KIRKLEES METROPOLITAN COUNCIL INVESTMENT & REGENERATION SERVICE

DELEGATED DECISION TO DETERMINE APPLICATIONS FOR CONSENT, AGREEMENT OR APPROVAL REQUIRED BY CONDITION

Reference No:	2022/44/91598/W
Site Address:	former, Stile Common Infant & Nursery School, Plane Street, Newsome, Huddersfield, HD4 6DF
Description:	Discharge of conditions 3 (Construction Management Plan), 4 (Construction Environmental Management Plan), 5 (road condition survey), 6 (Remediation Strategy), 9 (coal legacy) , 11 (estate roads), 12 (drainage under highway), 13 (highway retention), 14 (arboricultural method statement), 15 (Ecological Design Strategy), 16 (drainage scheme) and 17 (temporary drainage) of previous permission 2020/92067 for erection of 30 dwellings
Recommending Officer:	Nick Hirst

DECISION - Discharge of Conditions – Split Decision

Drg. No. 257/02/04.01	Rev B
--------------------------	----------

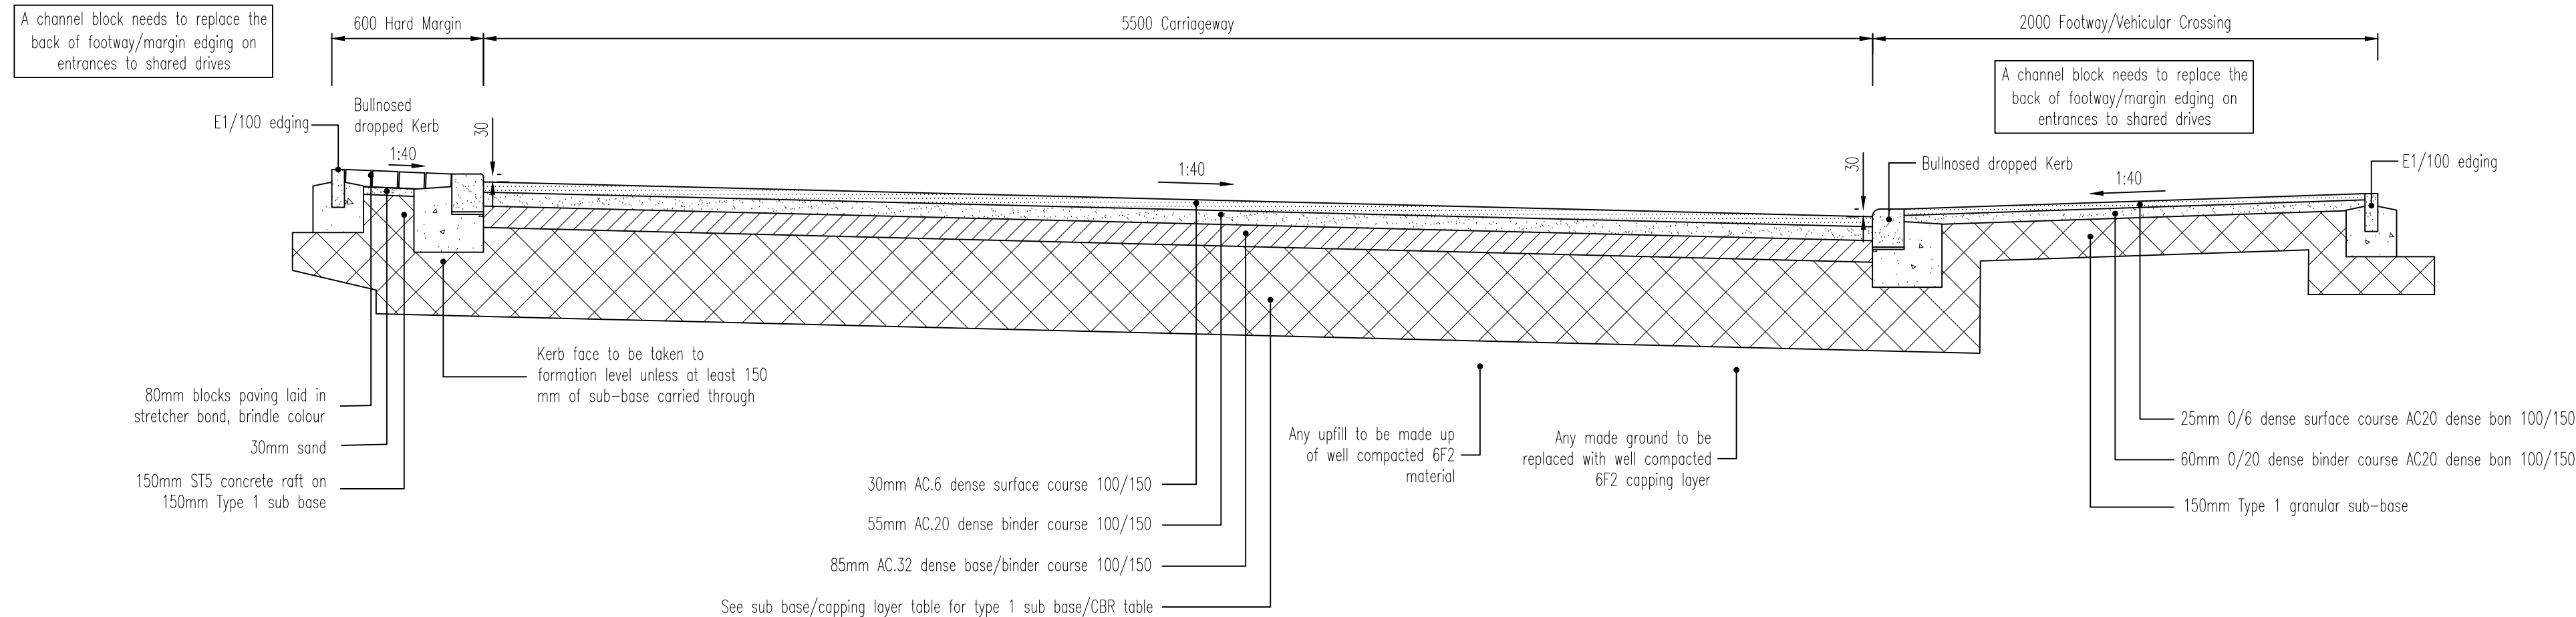
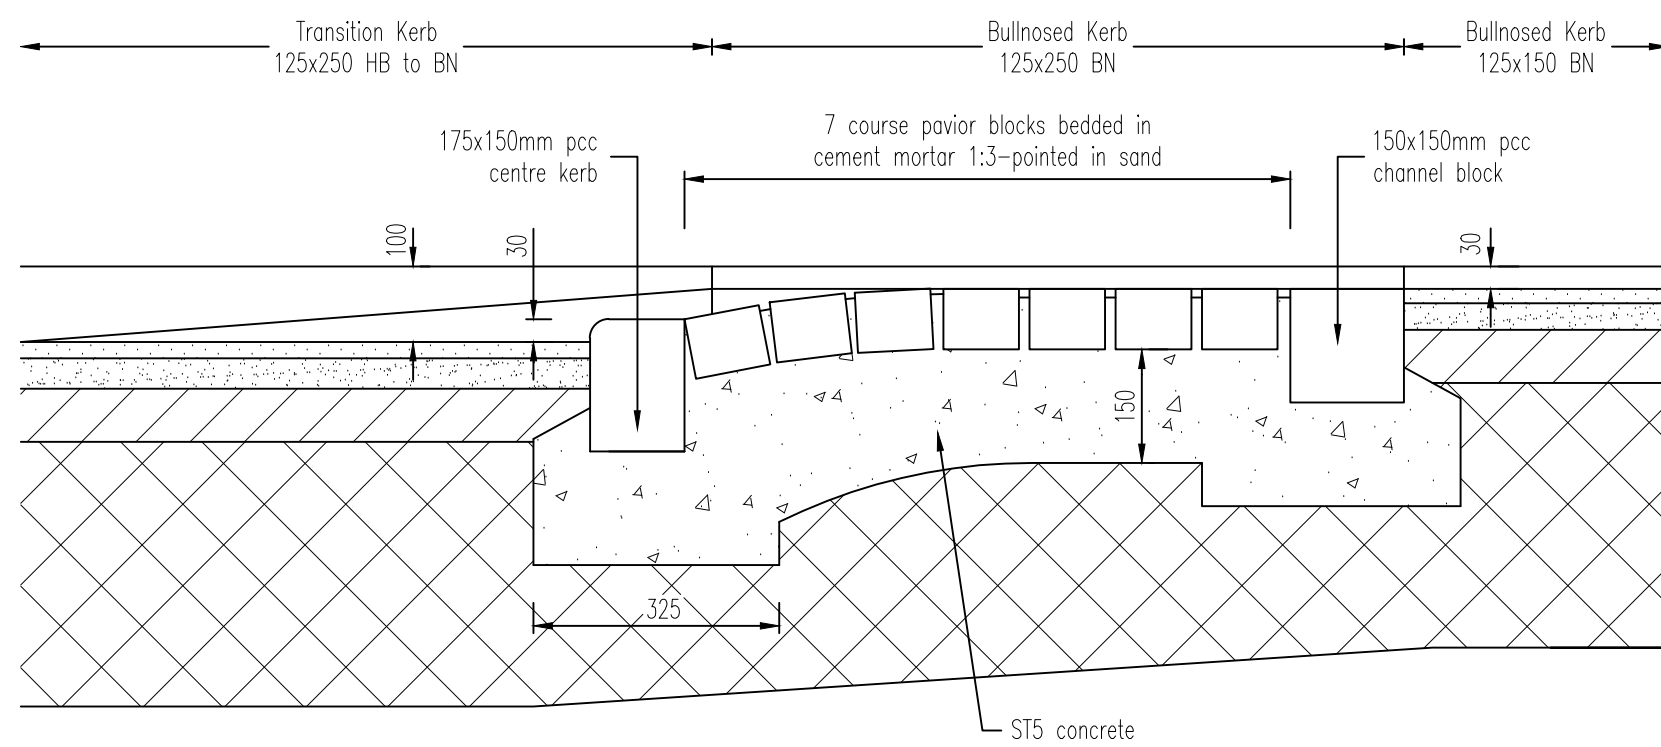
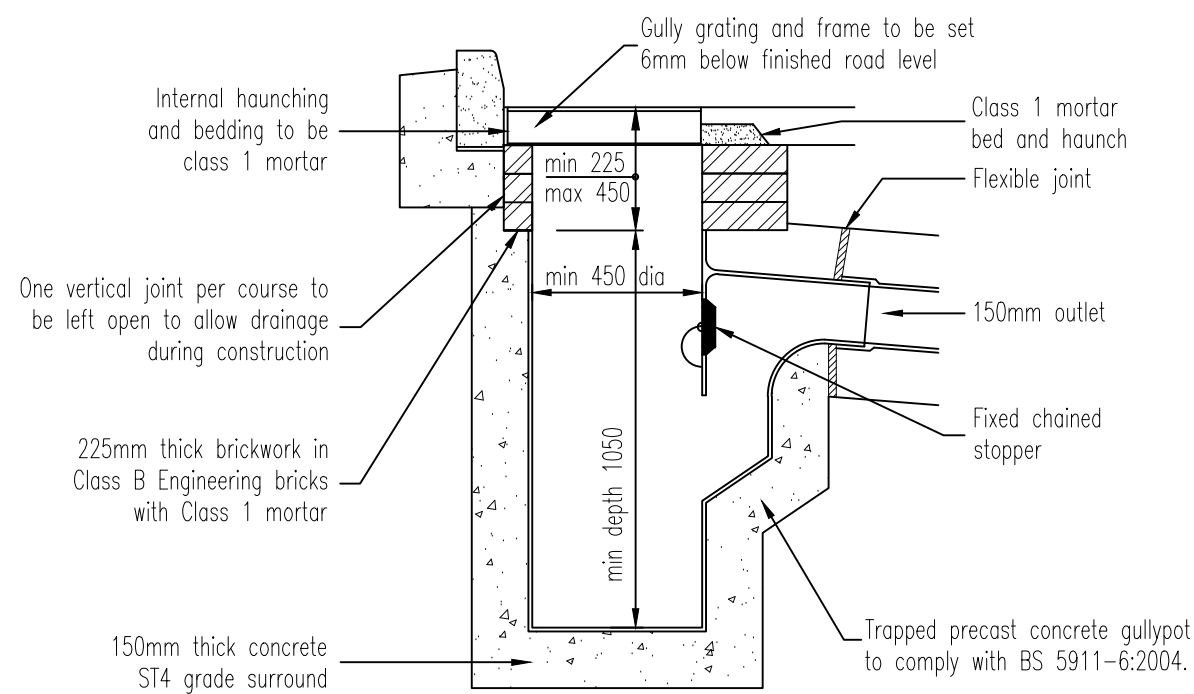
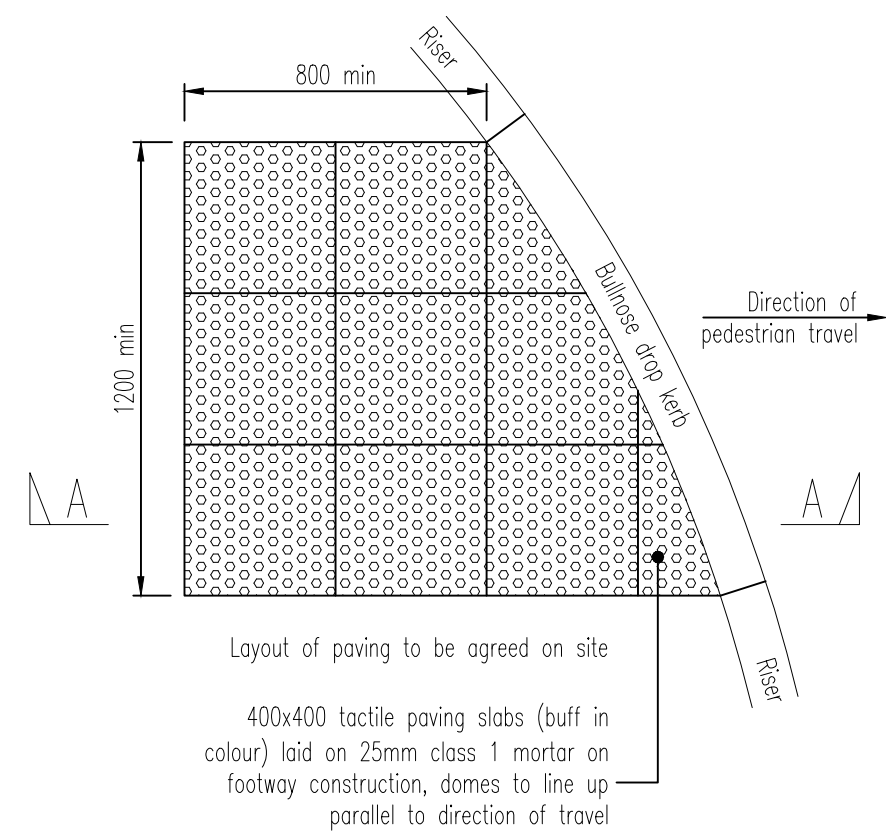
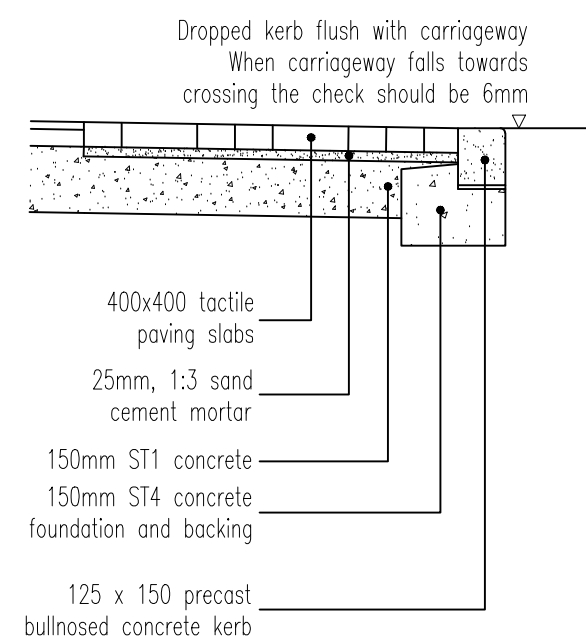
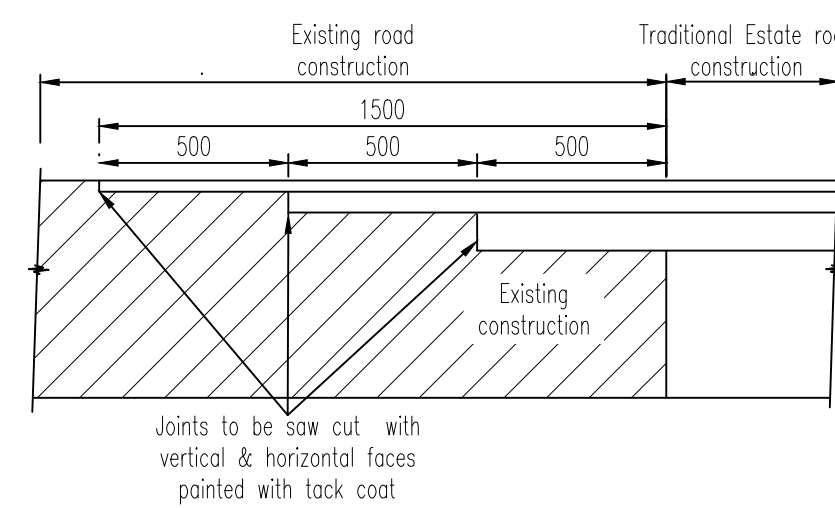
The submitted information is not accepted and does not meet adoptable standards. It is understood that discussions are progressing between the applicant and the Council's S38 department, but a conclusion is not imminent. Until such a time that the proposals reach an adoptable standard, officers are unable to discharge conditions 11 and 12.

APPENDIX A – SITE LAYOUT PLAN

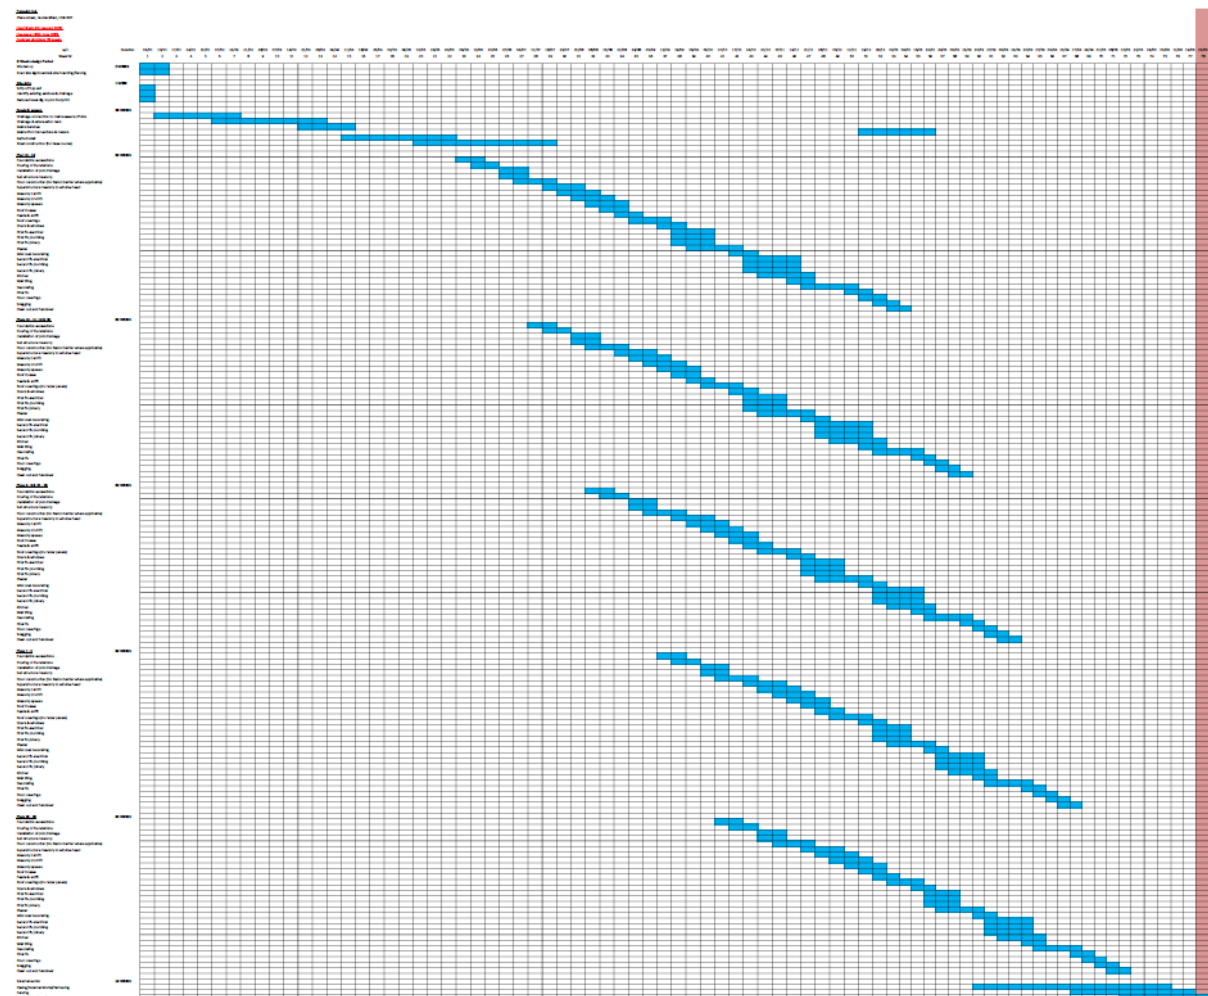
The condition requires a '*routing of construction traffic to and from the site*'. No such plan has been provided. While a parking area is shown, it is unclear how many spaces will be provided nor are details on expected demand given to demonstrate it is sufficient. Given the nature of Plane Street, officers consider it reasonable to require clarification how the applicant will seek to control parking upon this residential street. Finally insufficient commitment is provided regarding wheel washing, with an inadequate commitment to monitor it and may potentially use a wheel washing station and/or road sweeper.

- The condition requires details of '*routing of construction traffic to and from the site*'. No plan showing the route for construction traffic is shown. Such a plan should ensure construction vehicles remain on A roads for as long as practical, connecting to a motorway junction, and avoid villages and unsuitable smaller roads.
- A parking area is shown, but no details of the number of spaces it will provide are given. No information is provided on typical and maximum demand, to demonstrate that the parking spaces are adequate, nor is there any consideration of methods to prevent construction staff from parking on the residential Plane Street.
- Inadequate commitment to wheel washing and avoiding mud on the road is provided. A wheel-washer should be provided at all times, with its location to be shown on plan.
